Jeanie Bourke - Re: 44 Oak Street

From: Jeanie Bourke
To: Michael Chestnutt
Date: 7/24/2015 10:28 AM
Subject: Re: 44 Oak Street

A302

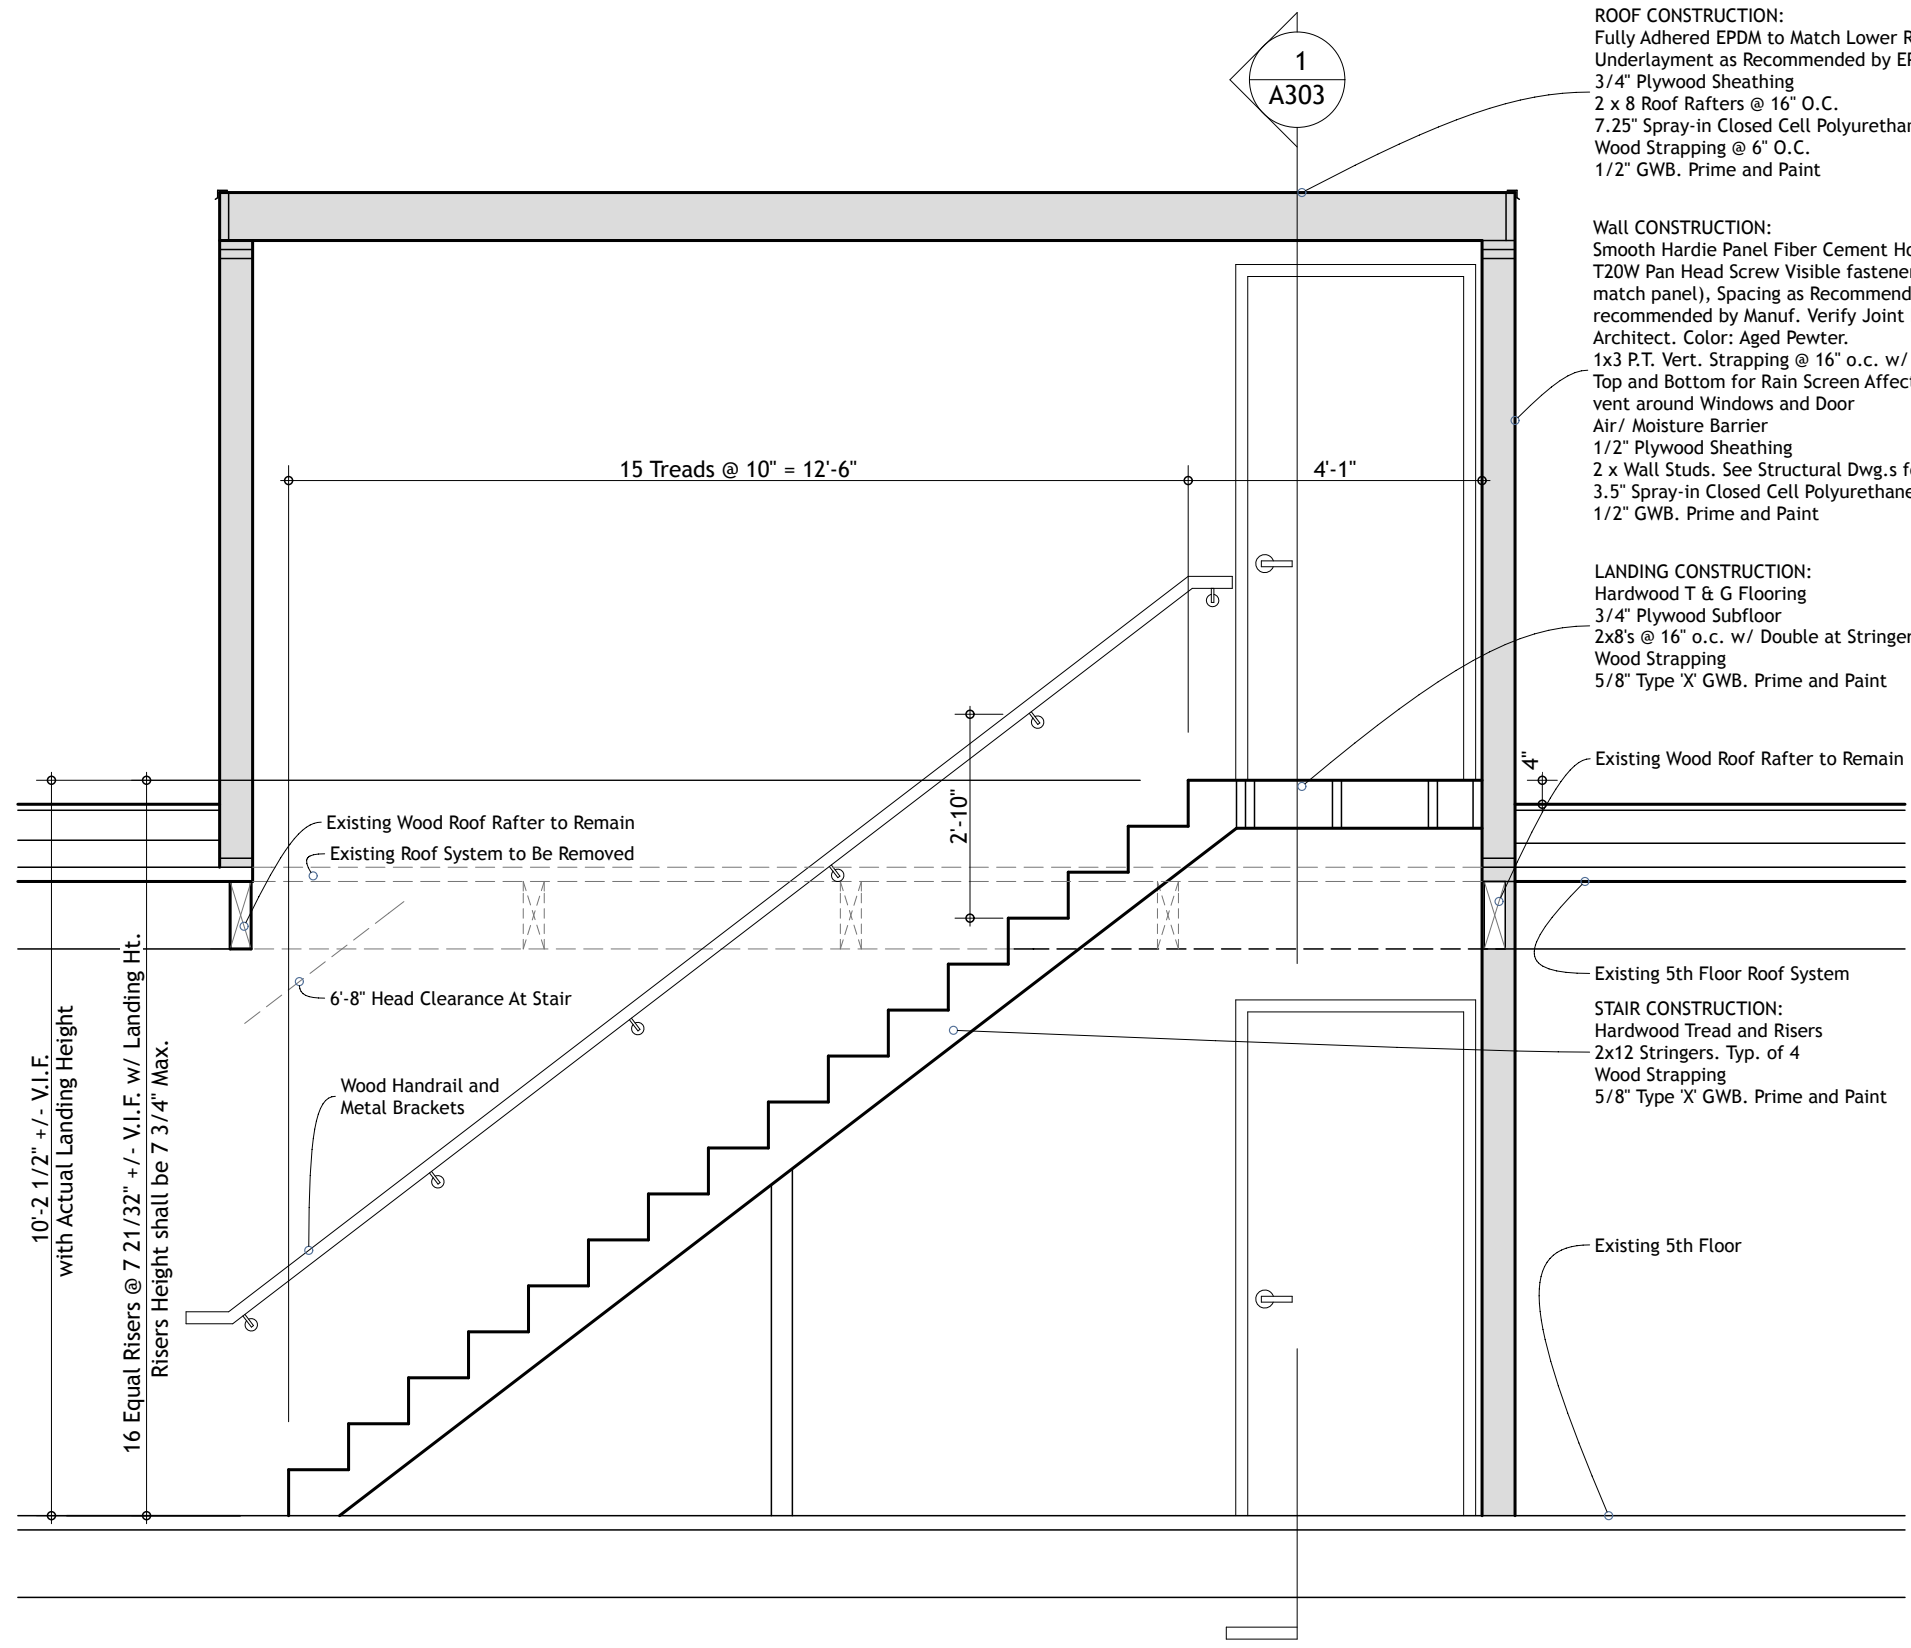
- Door to new roof deck stair and stair width shall meet code for occupant load of 49 people, which is 15". We have a 3'-0" door at the roof deck level and a 4'-0" wide stair.
- Enclose new roof access stair at the 5th floor level for smoke reasons so it is not communicating to the roof deck portion of the stair. This will require that we add a door from the unit to the enclosed stair "landing", this door (full lite french door, with weatherstripping @ perimeter) will be placed opposite the existing door to the existing exit stair.

I got your voice message also. This sounds good and makes perfect sense to have this stair essentially access the 1 exit enclosure as smoke proof.
